THE SOD GUY - SALES LOT

CONSTRUCTION DRAWINGS LOT 1, APPALOOSA HIGHWAY 24 SUBDIVISION

SALES LOT - SPECIAL USE
GRADING AND EROSION CONTROL PLAN

GEC_v1-redline.pdf Markup Summary

SALES LOT - SPECIAL USE
GRADING AND EROSION CONTROL PLAN

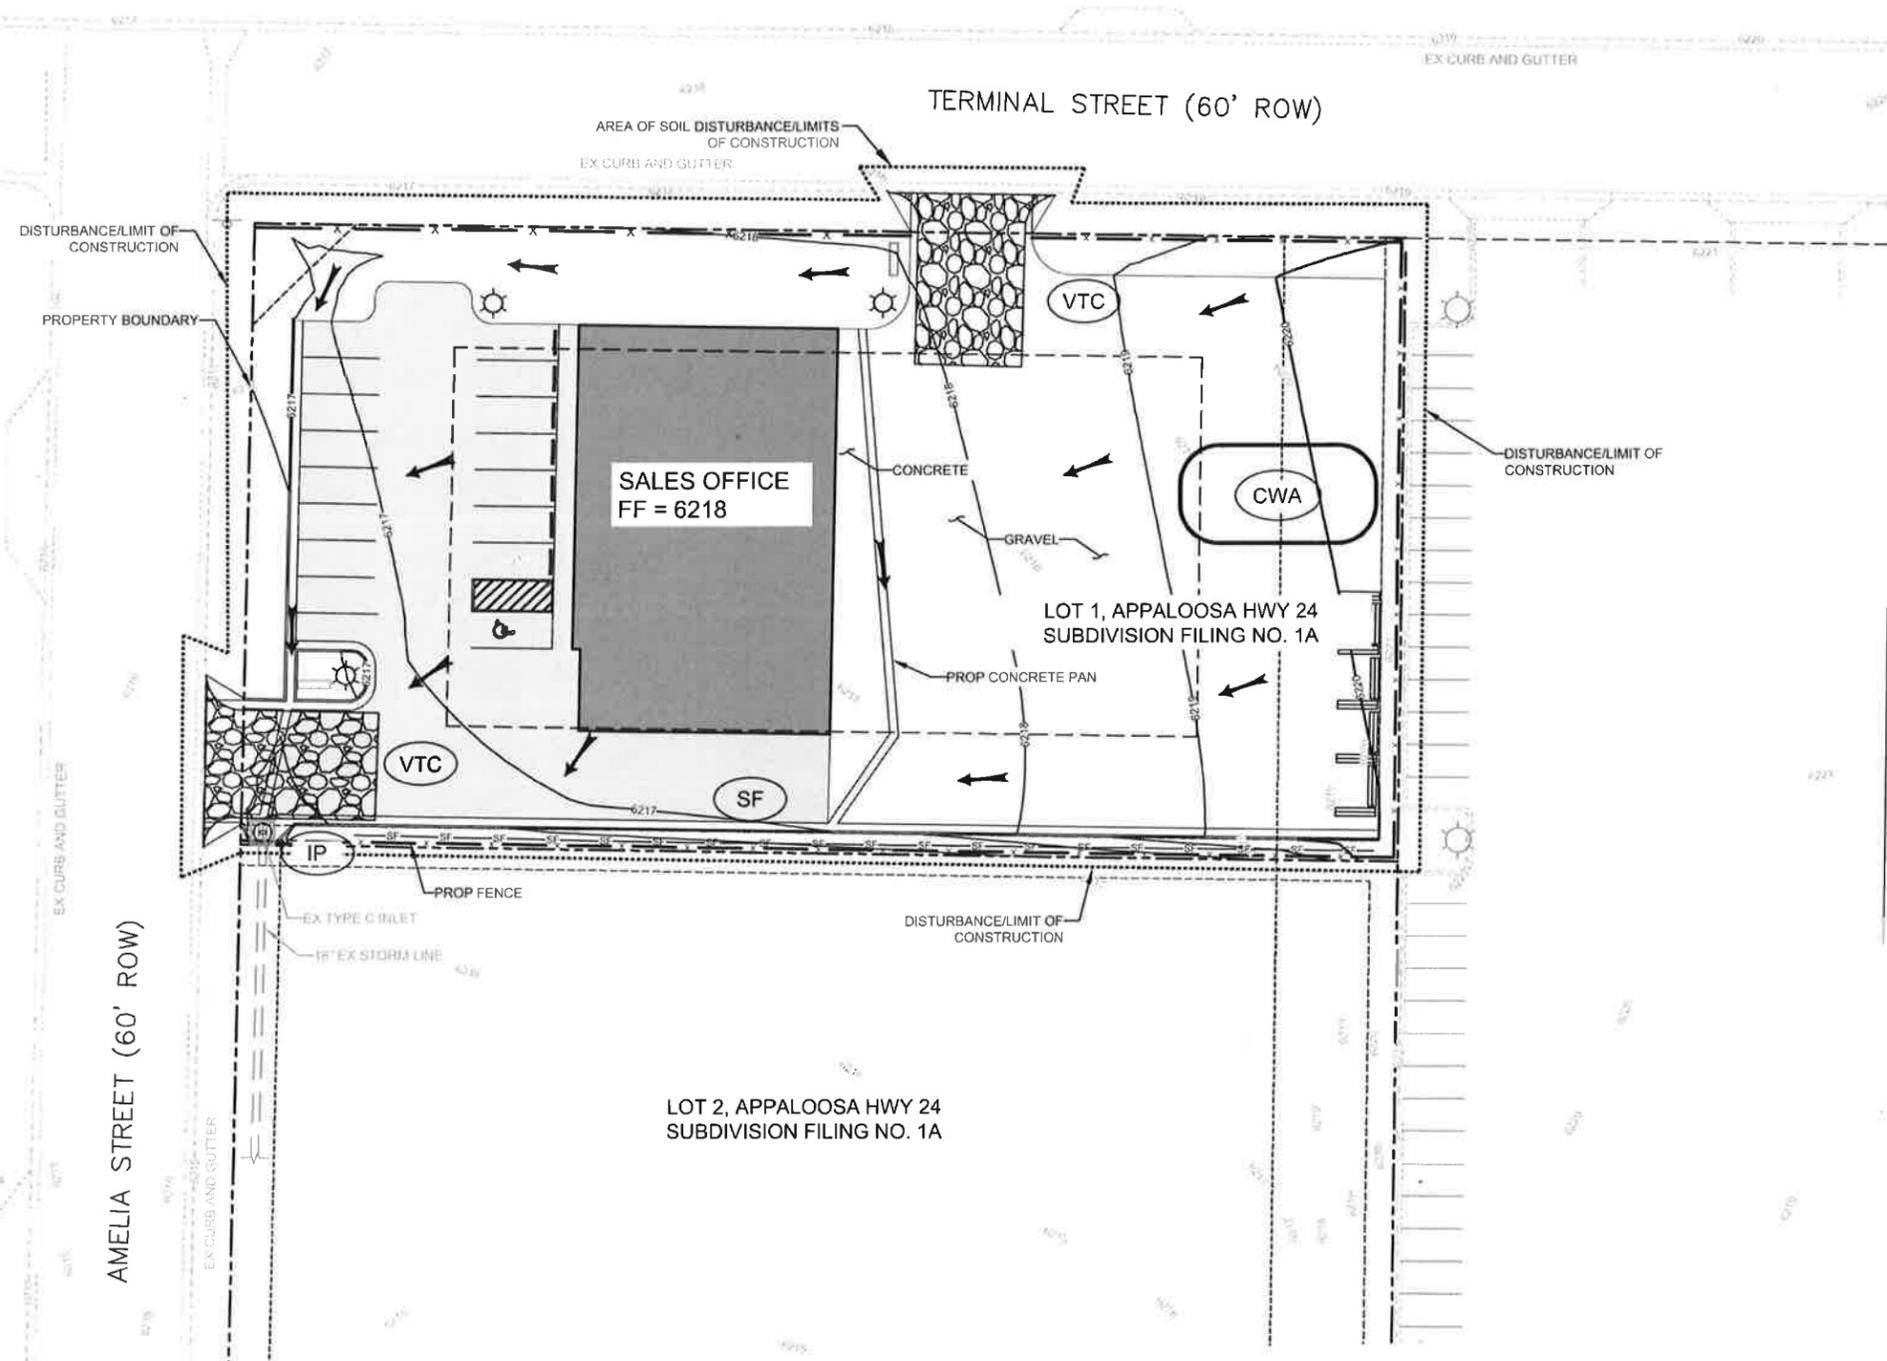
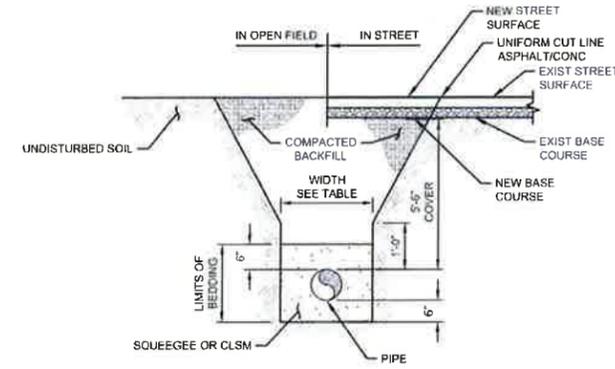
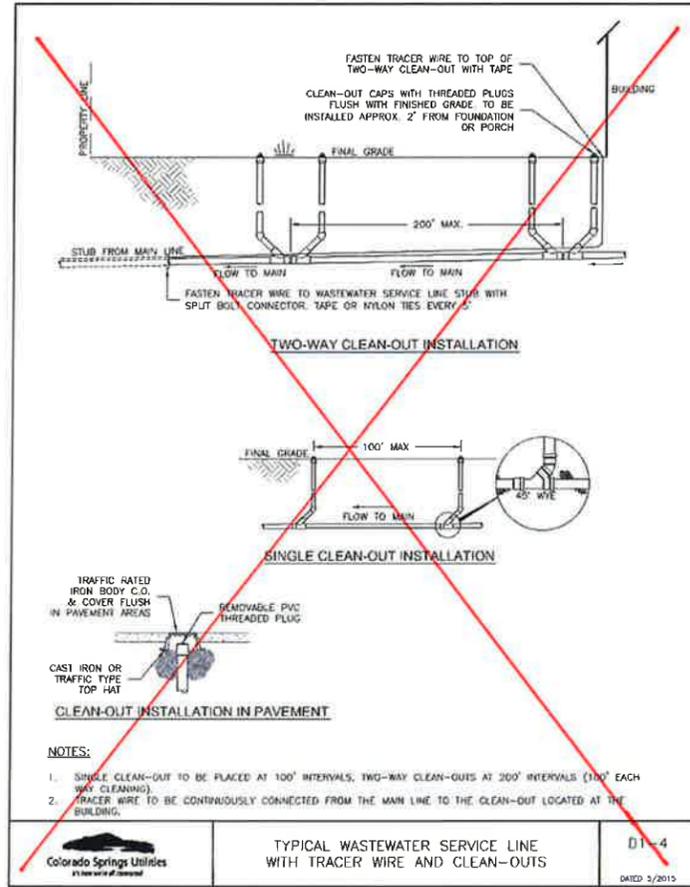
A SWMP must be submitted or a note provided on this grading and erosion control plan that a SWMP must be approved two weeks prior to the beginning of construction.

Provide the following on this plan:
-Vicinity Map
-Standard 27 GEC notes
-Construction BMP standard details
-Reference in note 26 to the geotech report submitted with VR1813
-Easements

Provide the details for the proposed access location and update the FAE accordingly.

Based on these contours, it appears that the water from this landscaped area is flowing off site. All water must flow to the inlet/detention pond for WQCV.

Based on this contour, it appears that the water from this landscaped area is flowing off site. All water must flow to the inlet/detention pond for WQCV.

Provide the detail for the concrete pan and show slope

Provide parking lot elevations

Identify this curb and gutter

Provide the slope of the handicap spot.

Show silt fence continued to the inlet. Update the FAE accordingly.

Provide the detail for the ditch here which conveys the stormwater to the inlet

Based on the grading shown along the southern property line, it does not appear that the stormwater is reaching the inlet to the detention pond. All stormwater from the site must be treated for WQCV.

Is this an error with the contour?

Include all line types in the legend.
